APPLICATION NO. 09AA-1011071011 PROJECT NO. 1003062
 PROJECT NAME SKYVIEW CENTER
 EPC APPLICATION NO.
 APPLICANT / AGENT SCOTT STEFFEN | PHONE NO. 823-1000
 ZONE ATLAS PAGE C-2
 (SDP for SUB), (SDP for BP), (FINAL PLATS), (MASTER DEV PLAN), (IR), (AA)

ONE STOP COMMENT FORM LOG

Re: Modifications to Amended Site Development Plan for Building Permit:
CVS at Indian School and Tramway

Re: Administrative Amendment Request: Proposed CVS at the Northeast Corner of Indian School and Tramway

DRAWING BY: B.JG/Lsm
 DATE: DECEMBER 2009
 JOB NUMBER: 090374
 TITLE:

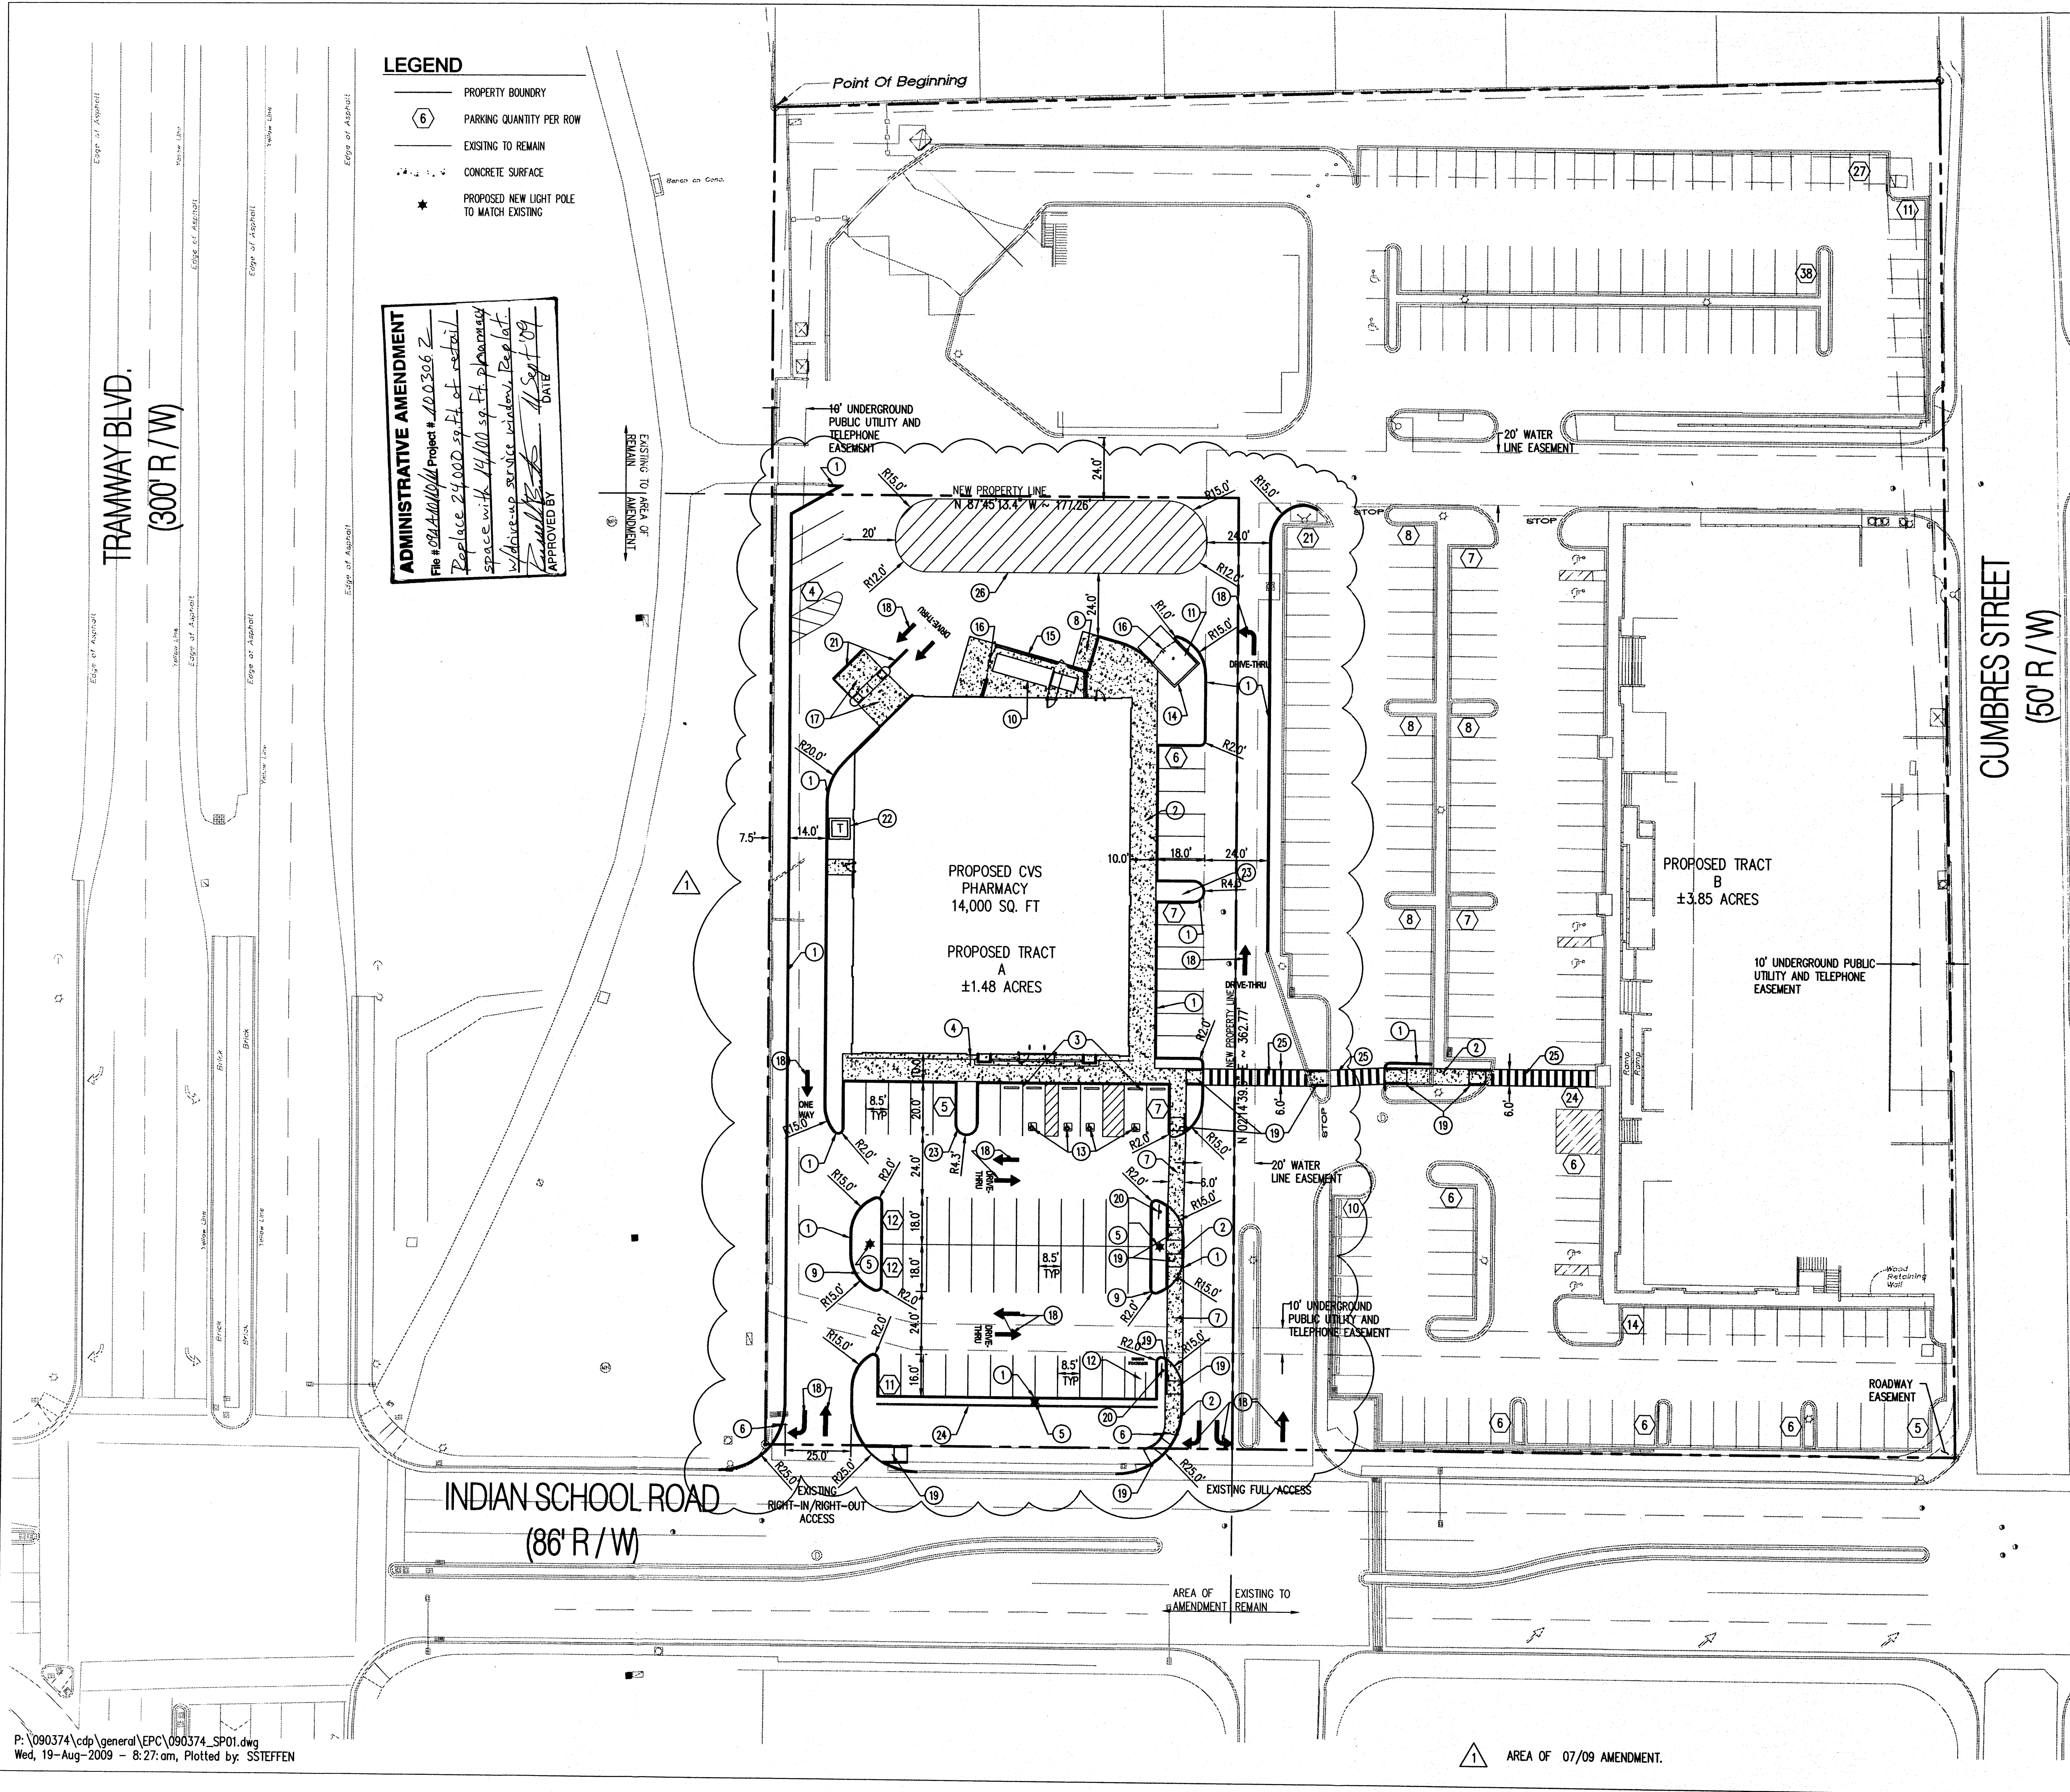
*• why 41 notes?
• should be 26 notes
based on Sept. 09 approval
• submitted wrong reference -
(11-09 AA pertains to
replat, not SPBP)*

Per our discussion on Friday, June 3rd, 2011, the purpose of this letter is to describe the reason for eliminating two ramps proposed to be built within the new pedestrian connection linking the subject CVS Pharmacy to the existing shopping center east of it. As we discussed, this pedestrian connection was required to be added as a condition of the Administrative Amendment approval dated November 3, 2009.

With the above information as a background, the Administrative Amendment drawings approved in November of 2009 indicate that 2 ramps (keyed note 19) would be built along the pedestrian connection route in a parking end aisle landscape median (see attached). These ramps are not necessary and this request is to eliminate them and construct the walkway flush with the drive aisle surface through the median. This will result in a better pedestrian walking experience as they won't be forced to maneuver up a steep ramp and then down again approximately 40' away. The enclosed drawings indicate this modification.
